**From:** [Damiano Boscolo](#)  
**To:** [Rachael Stevie \(CD\)](#)  
**Subject:** RU 22-00002: East Peak Reasonable Use Variance comments  
**Date:** Wednesday, April 20, 2022 12:14:21 PM  
**Attachments:** [image.png](#)

Thank you for providing an opportunity to comment on East Peak Reasonable Use Variance. East Peak Development, LLC is requesting a reasonable use exception to the 150-foot buffer and 15-foot setback for a Type III wetland and the 50-foot buffer and 15-foot setback for a Type Ns stream. In my opinion the "Reasonable Use Variance" should not be granted without additional consideration.

EX-2
SHEET

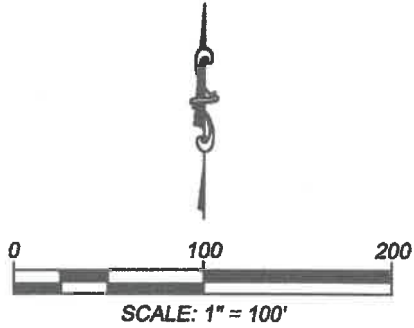
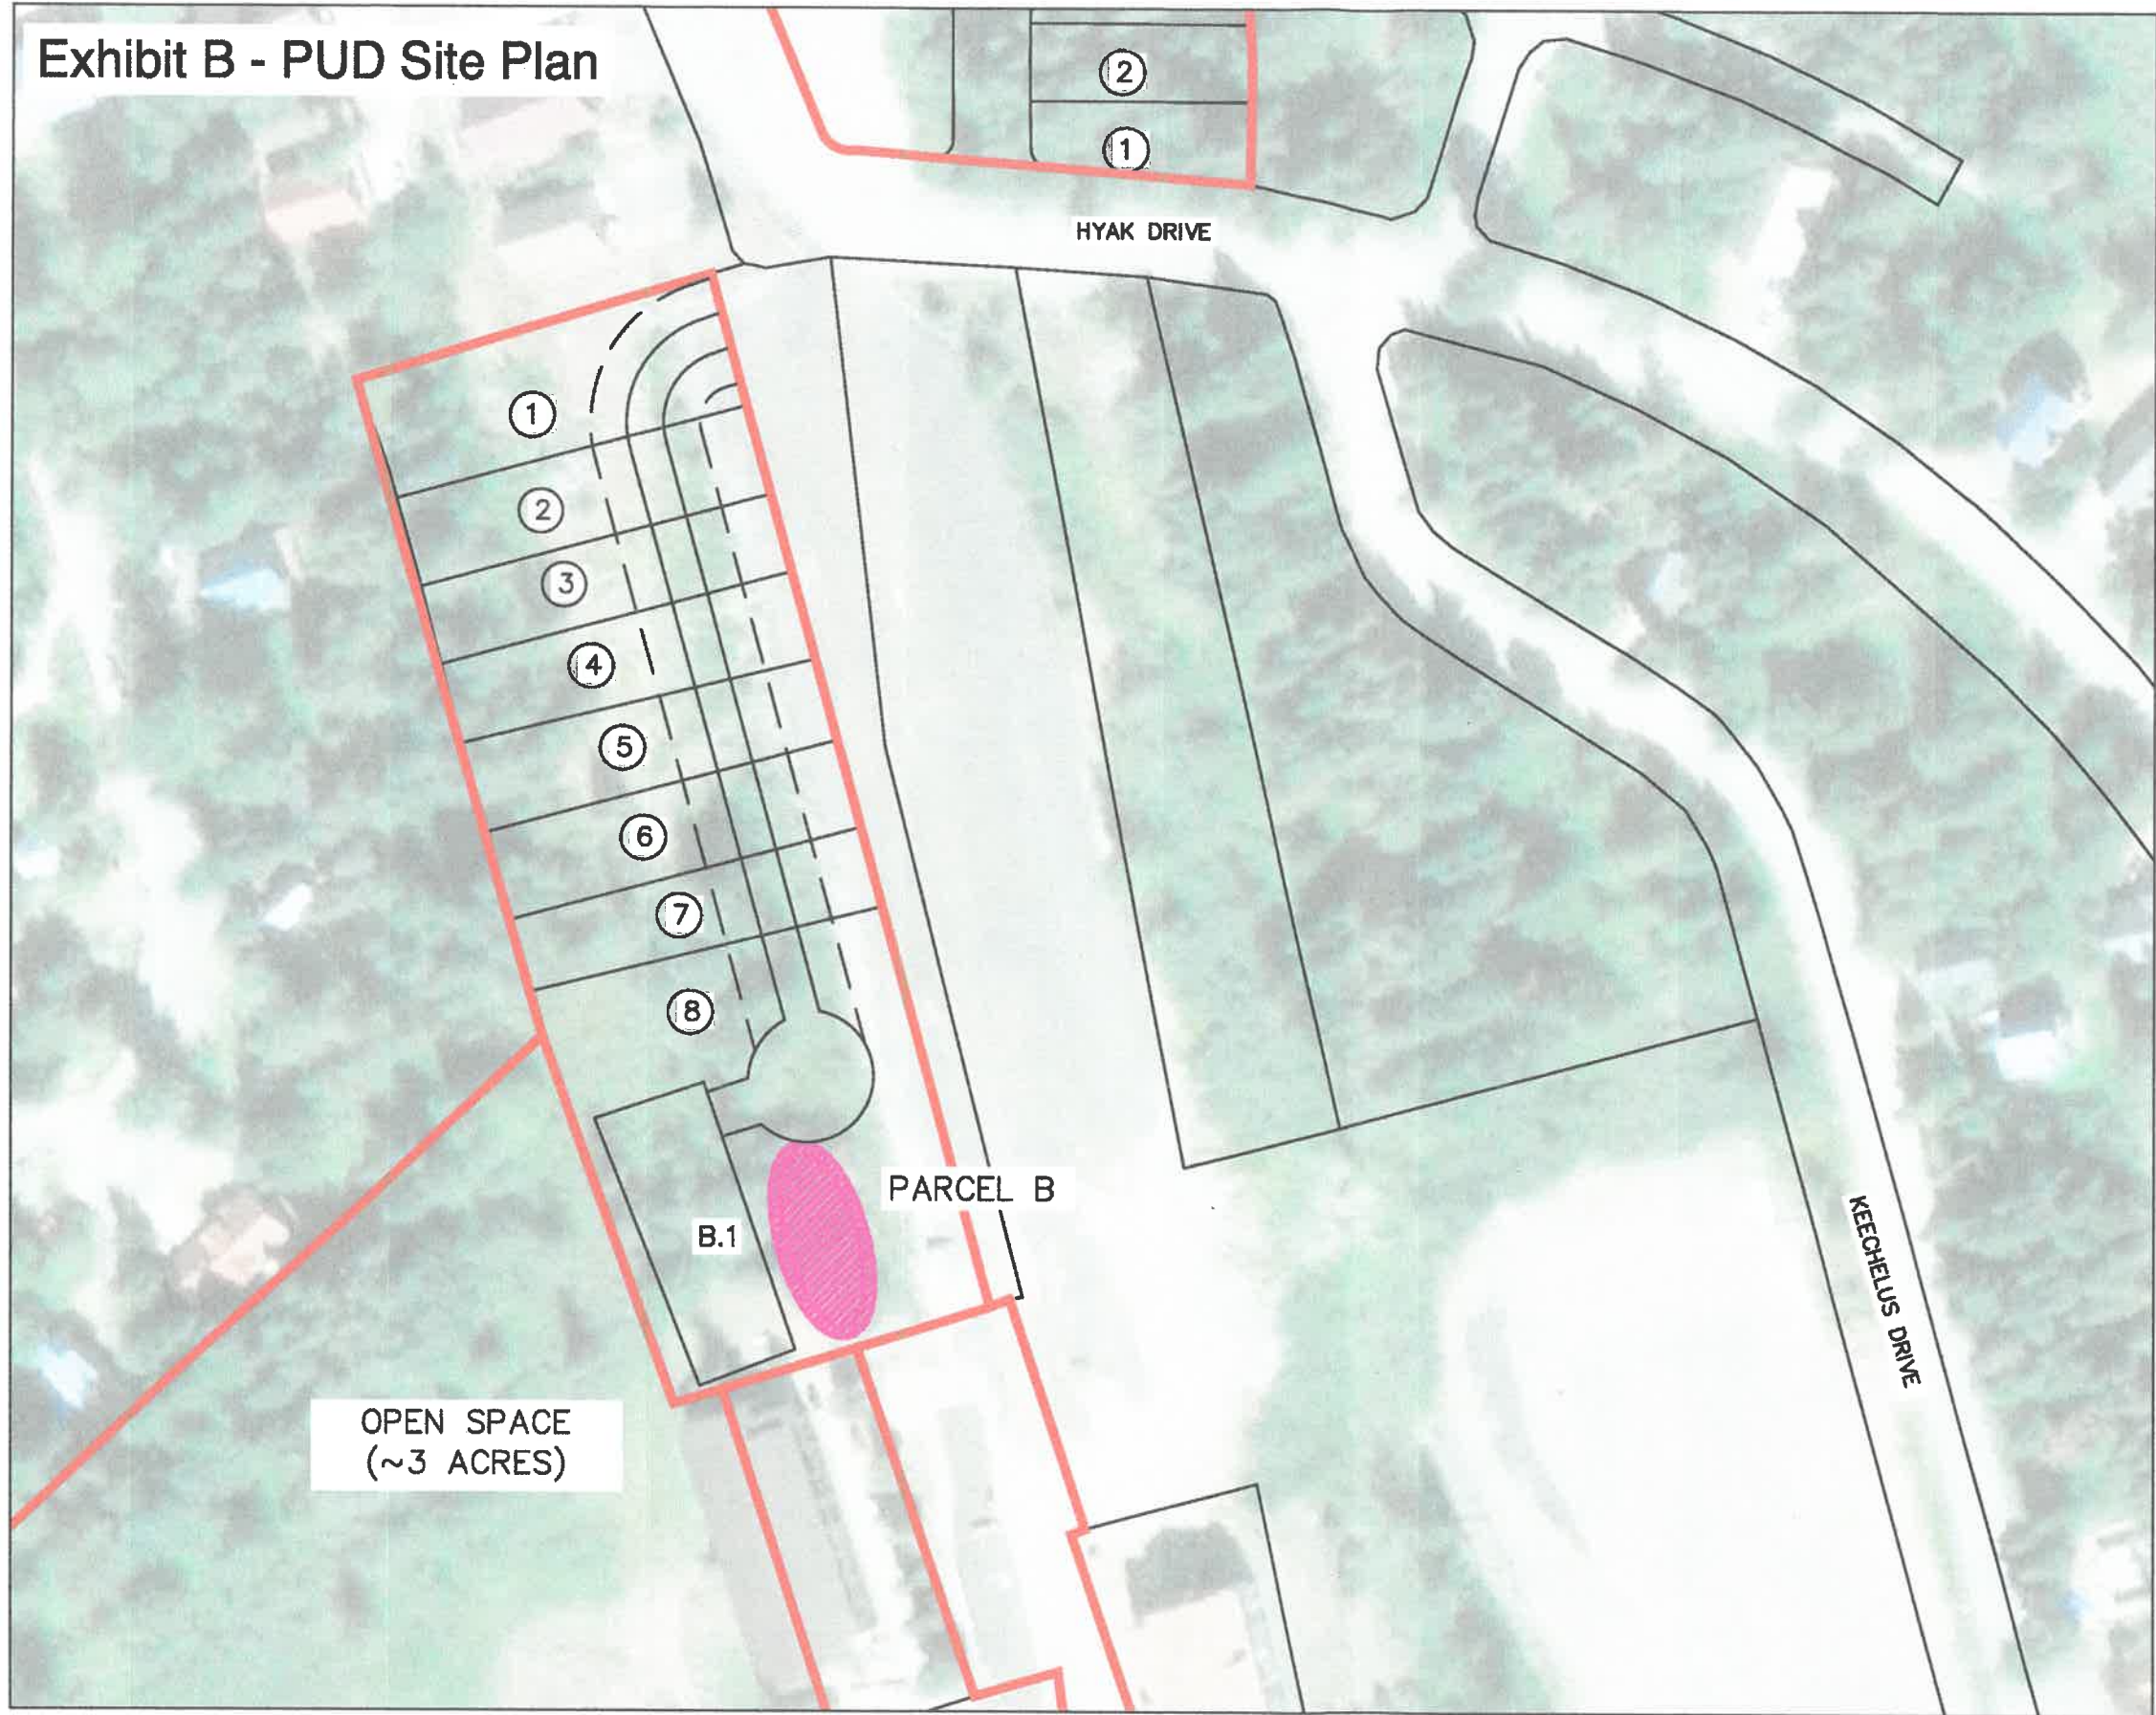
**Response: The applicant proceeded with a Partial Final Development Plan for Divisions 1 & 2 and received final approval for the Partial Final Development Plan and Divisions 1 & 2. The applicant submitted documentation from a consultant stating no wetlands were present satisfying this condition in order to receive approval for Divisions 1 and 2. Furthermore in reviewing the County wetland mapping there seems to be no identified wetlands on the project site. In review of the County file for the Hyak Amended PUD there is some references to a wetland located above the existing Sundance building. This area was formerly labeled as Area B of the Hyak Amended Planned Unit Development original map. Currently this area is in the process of being purchased by Sundance therefore no development, by the Hyak Planned Unit Development, will occur. The area of purchase by Sundance is considered open space. See Exhibit 4, specifically Sheet EX-2. Furthermore there is no required condition regarding wetland mitigation within Ord. 94-12.**

In reviewing the Hyak PUD Final Development Plan approved in 2018, Kittitas County required a wetland mitigation plan for all identified wetlands. East Peak Development states in the project narrative for the 2018 Hyak PUD Final Development plan (shown above), that documentation from their consultant stated no wetlands were present, satisfying the

EXHIBIT A - PROPOSED SITE PLAN

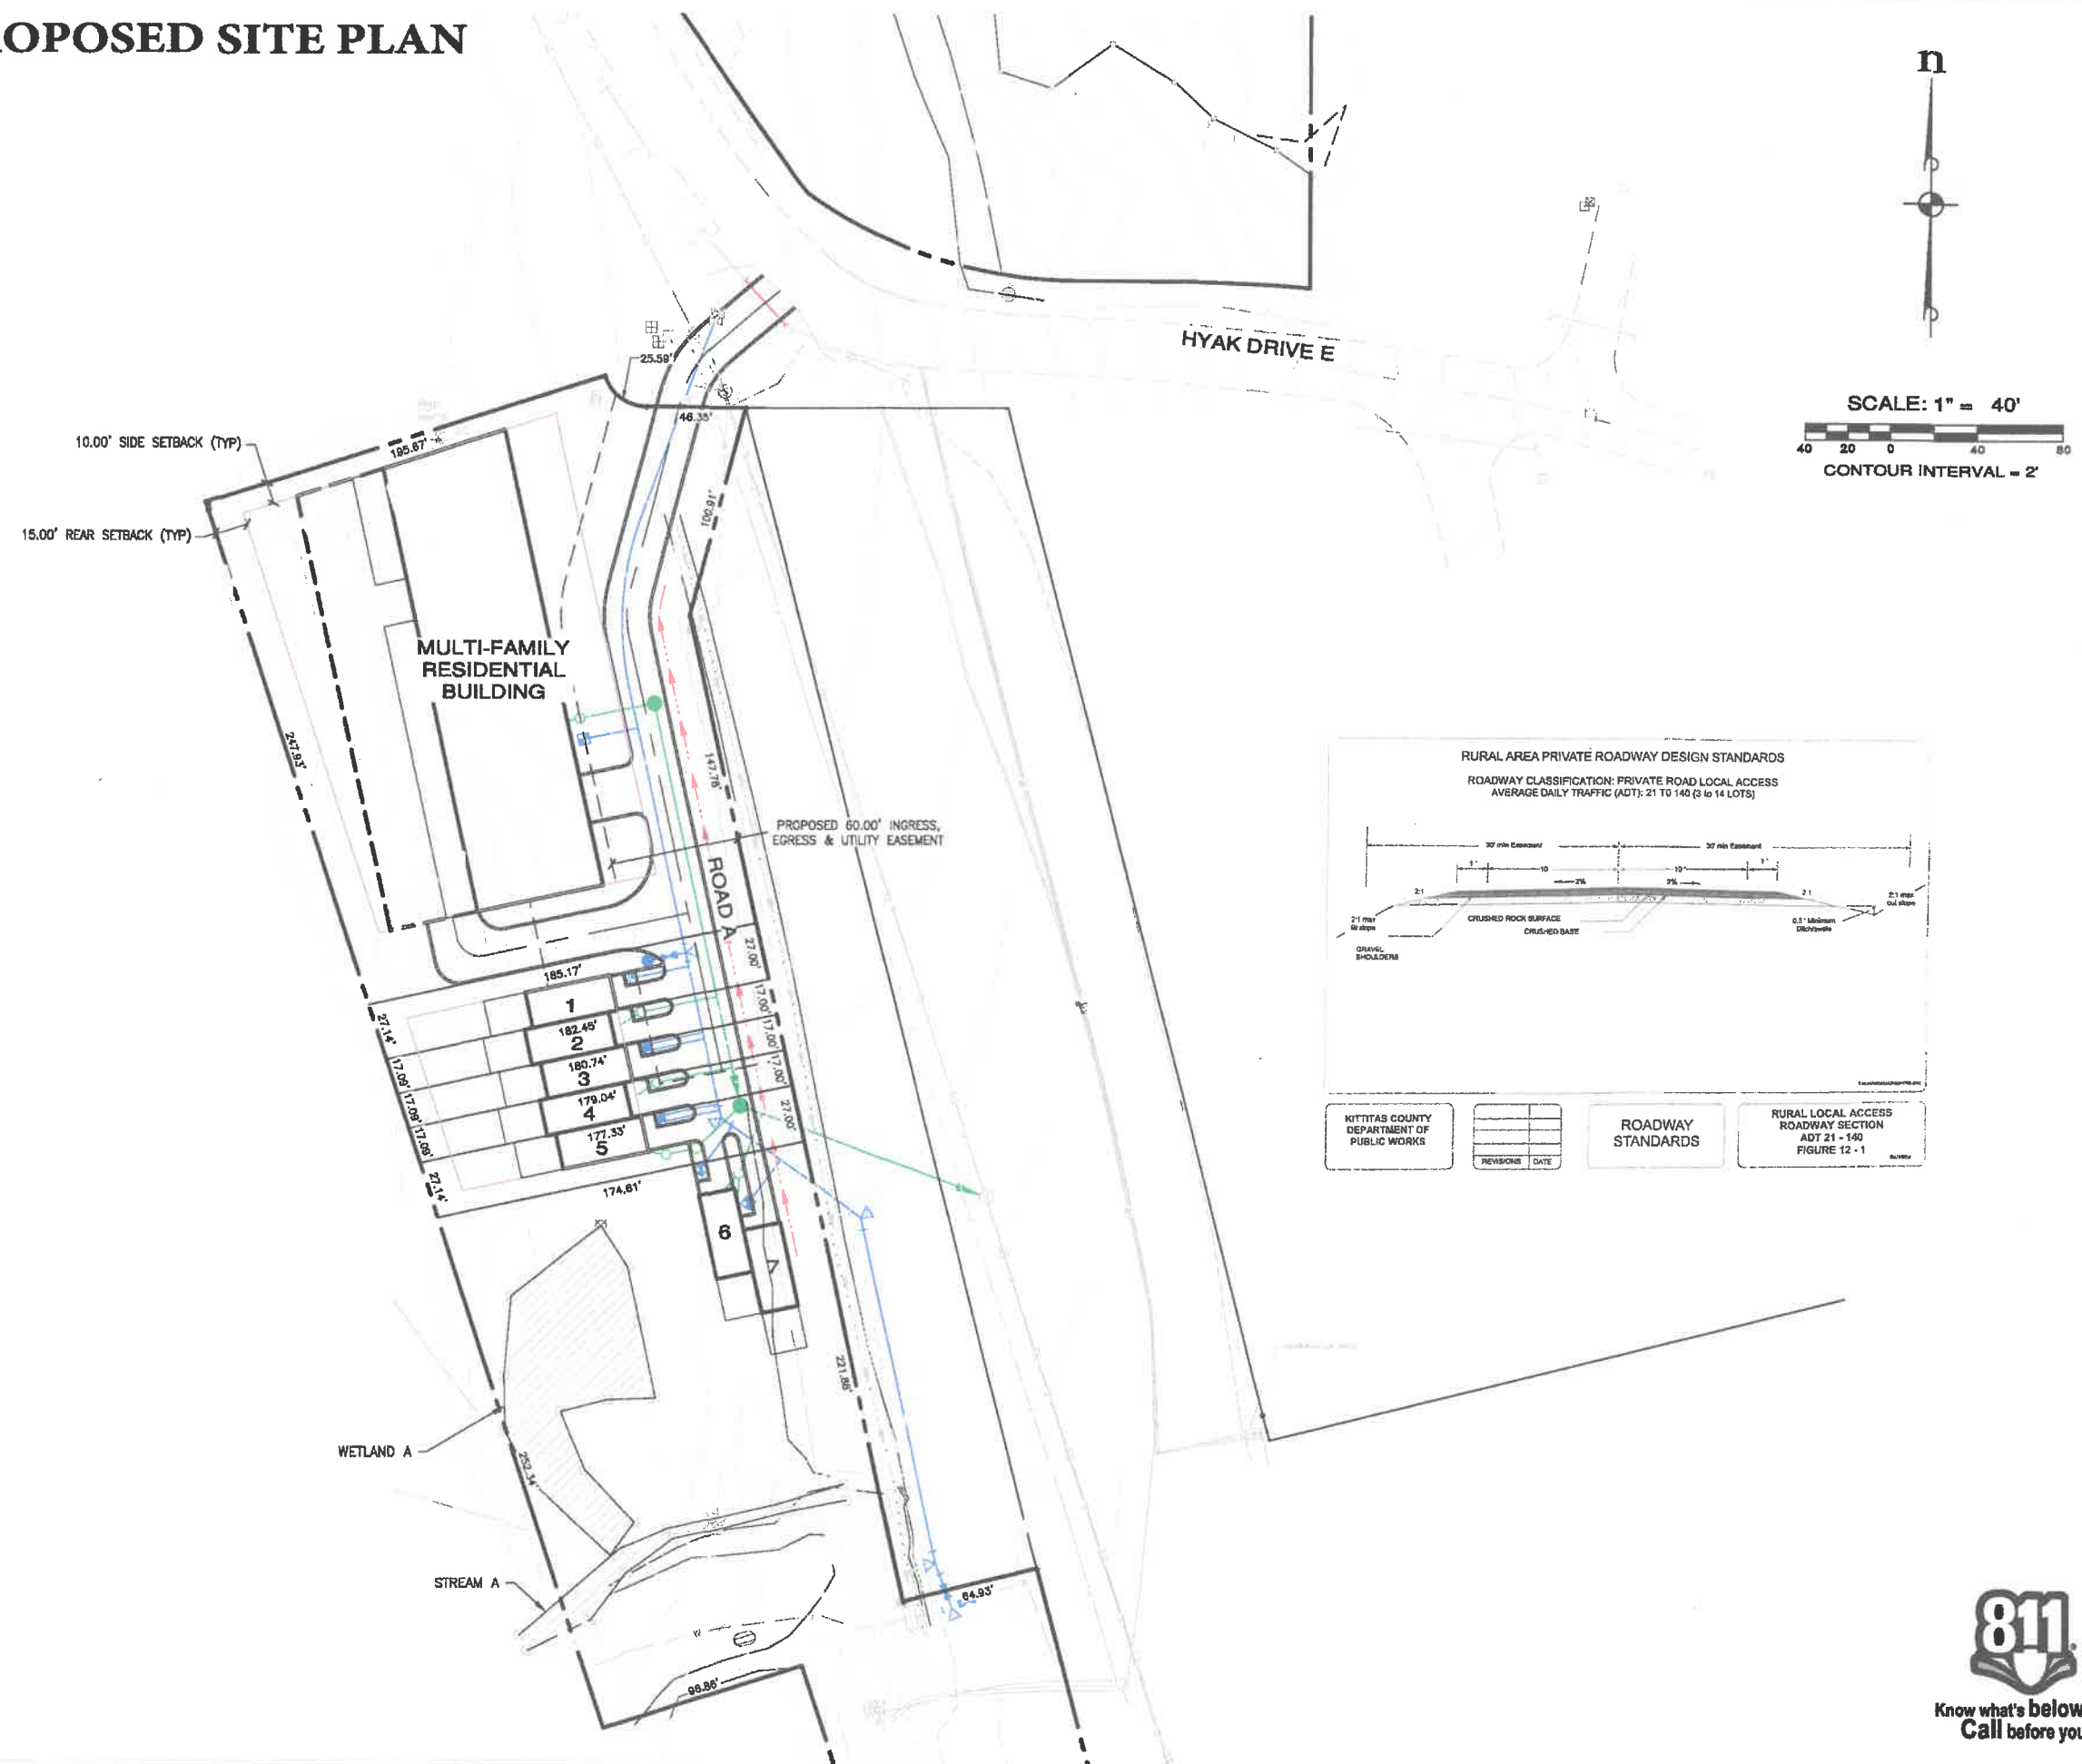
**Counter response to Project Narrative 10 B.** East Peak Development, LLC states in their response that "the application looked at a number of site layout and the Site Plan (Exhibit A) presented in this application is the most efficient and condensed plan to achieve the reasonable use of the property." This may be true however, the condensed plan from 8 single family lots to 7 attached units still has a significant portion of the 7 attached units within the wetland buffer. A more reasonable response would be to construct the 50 unit condo building at the north-end of the property and vacate the plan to construct the 7 attached units within the wetland buffer.

**Counter response to Project Narrative 10 C.** East Peak Development, LLC states in their response "The application has taken significant measures to minimize the impact of the development on the critical areas". Again, the answer is clearly NO. All 7 of the attached units are within the 150-buffer. A reasonable use would be to vacate the plan for the 7 townhomes.
